# CITY OF ALBUQUERQUE

December 28, 2022

**RE: Rasining Cane's #972**  
**Tract 3, UNM Gibson Commercial District 2011C-138**  
**NEC Gibson & Alumni SE, Albuquerque, NM**  
**Grading Plan and Drainage Report**  
**Engineers Stamp Date: 12/01/2022**  
**Hydrology File: L15D051A**

Based upon the information provided in your submittal received 12/08/2022, the Grading & Drainage Plan is **not** approved for Grading Permit. The following comments need to be addressed for approval of the above referenced project:

C3.1

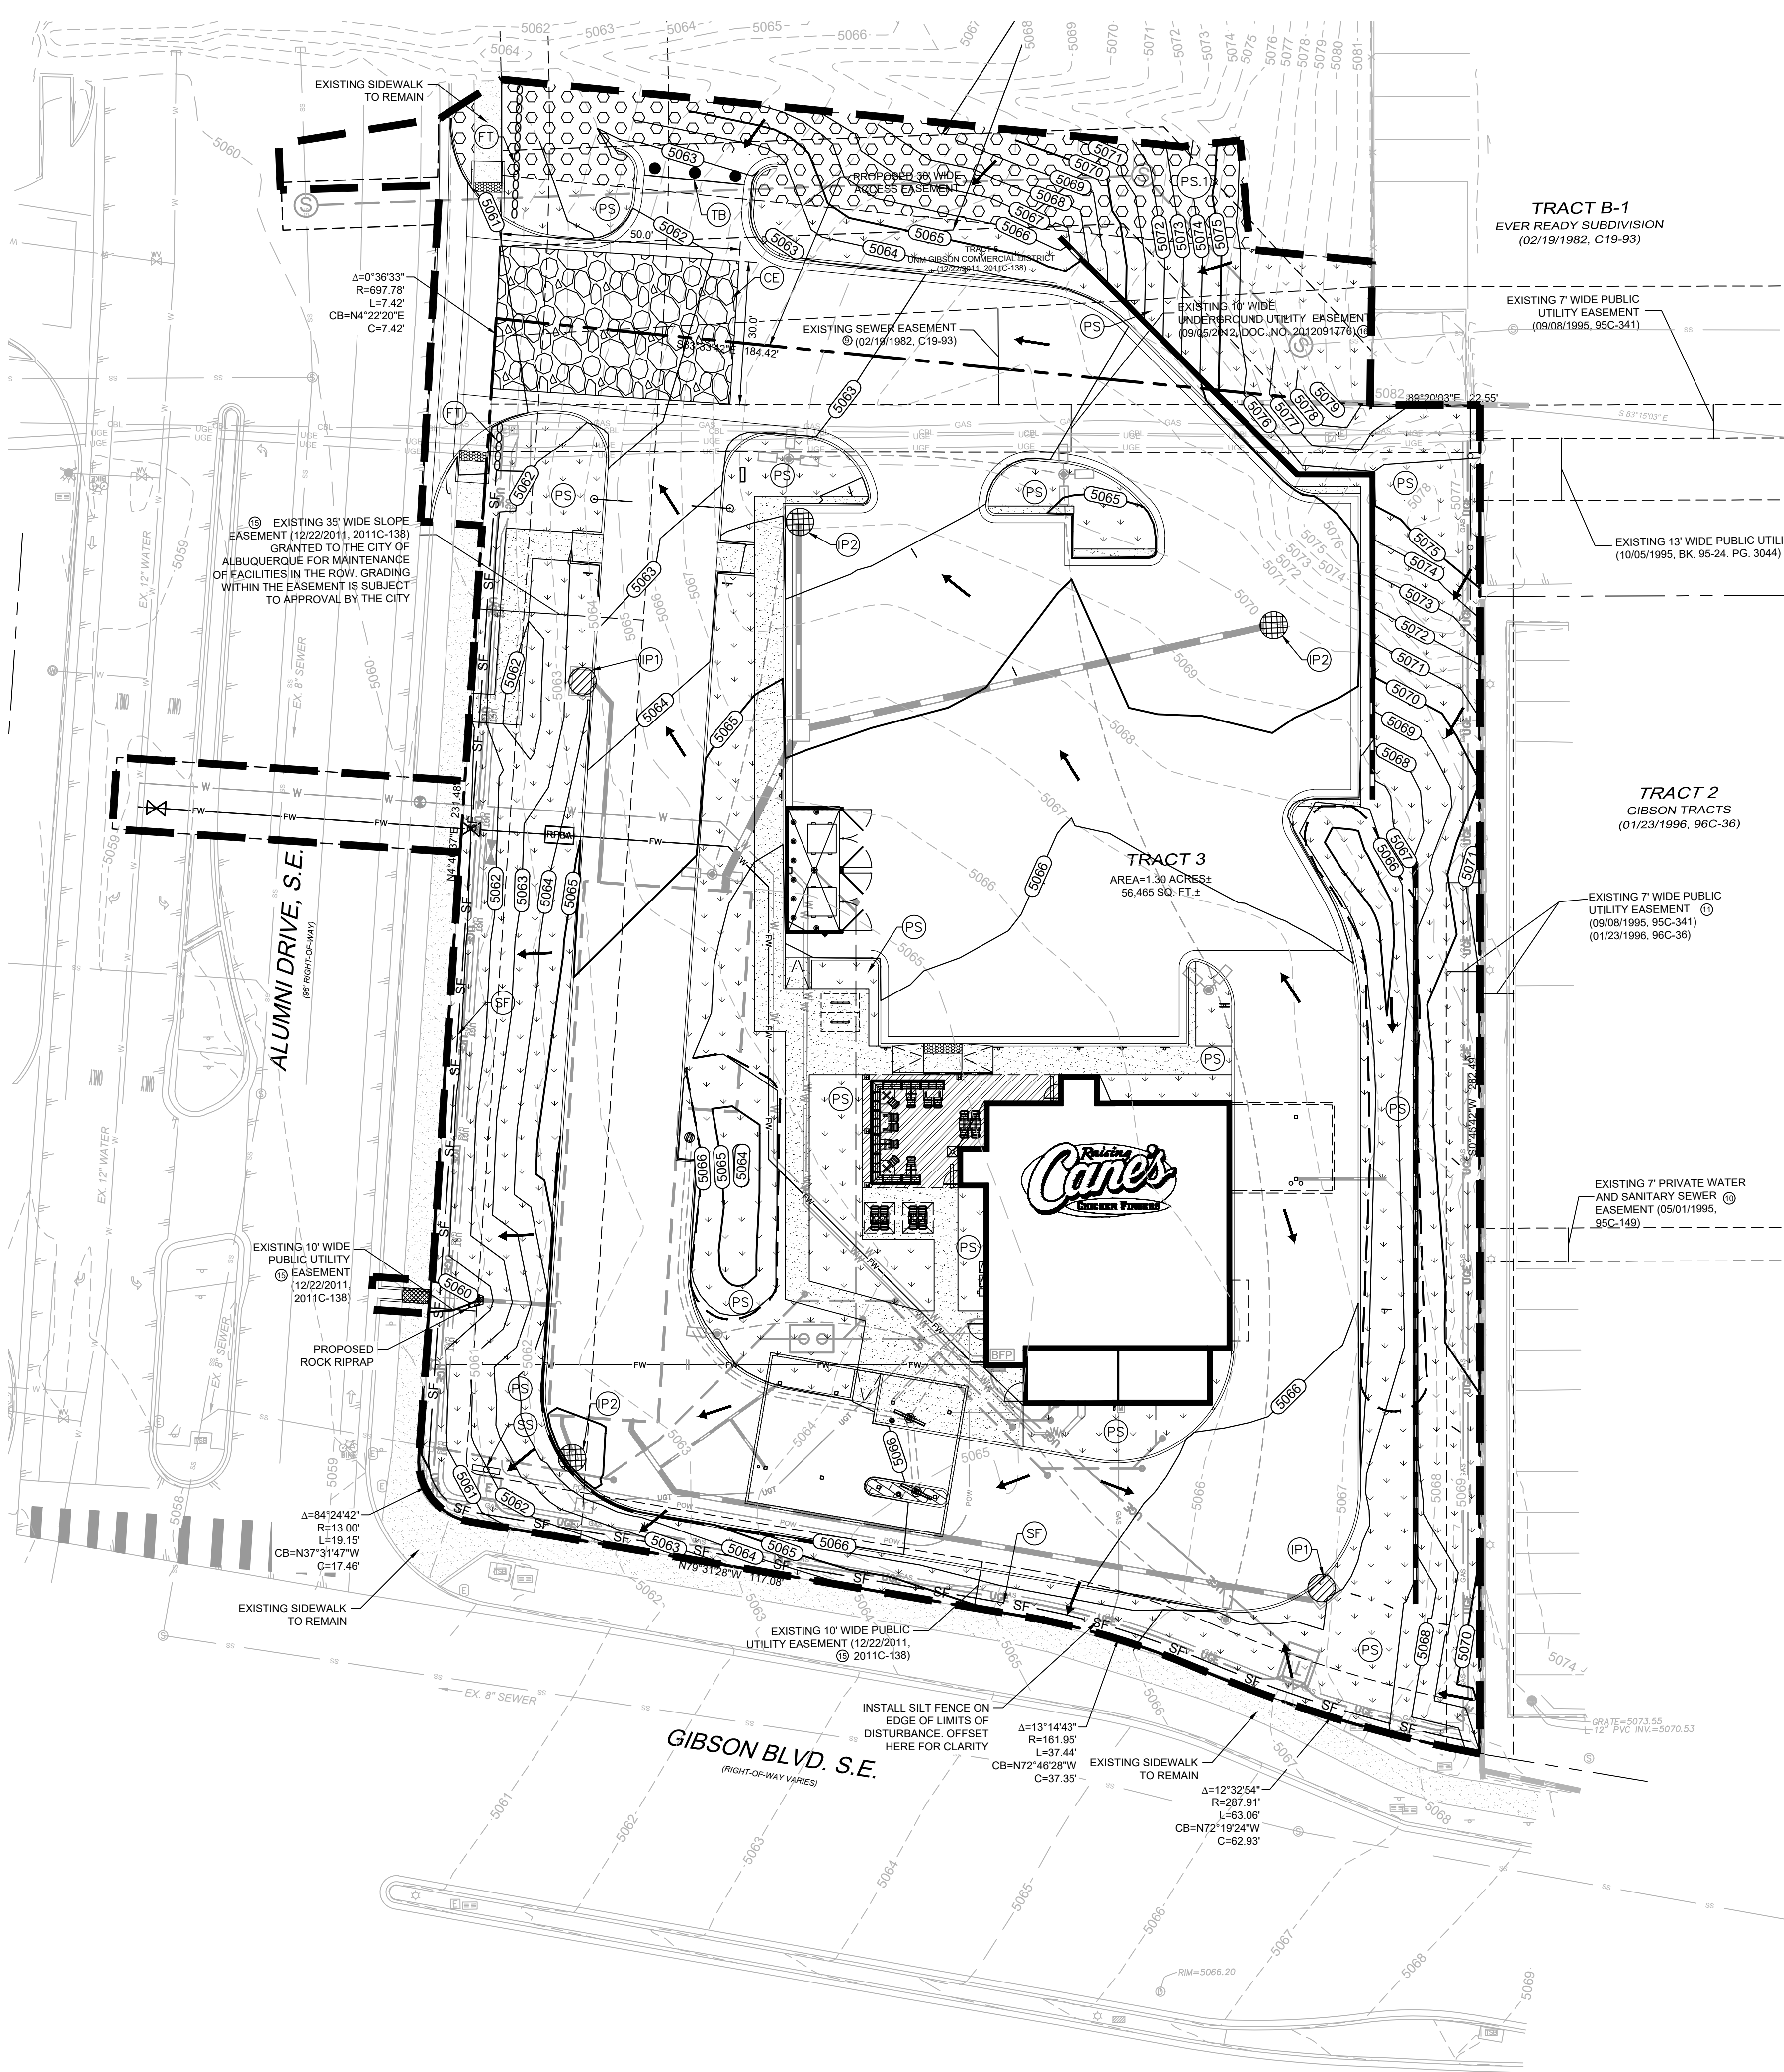
1. Please define Areas 1, 2 & 3 in Hydrograph for Small Watersheds on the drainage report and show their locations on the plan.
2. Provide the detail sheet referred by SF, IP1 & IP2 on sheet C3.1.
3. Provide the underground detention pond details including volume calculations. Where are the 36" pipes that the build notes referred on sheet C6.3? Add station number and FL elevations for SD line C to the detention pond.
4. Add erosion protection between SD line A daylighting outfall and the proposed sidewalk culvert on sheet C6.3.
5. Add SO-19 notes (attached) on the plan.
6. Drainage covenant will be required.
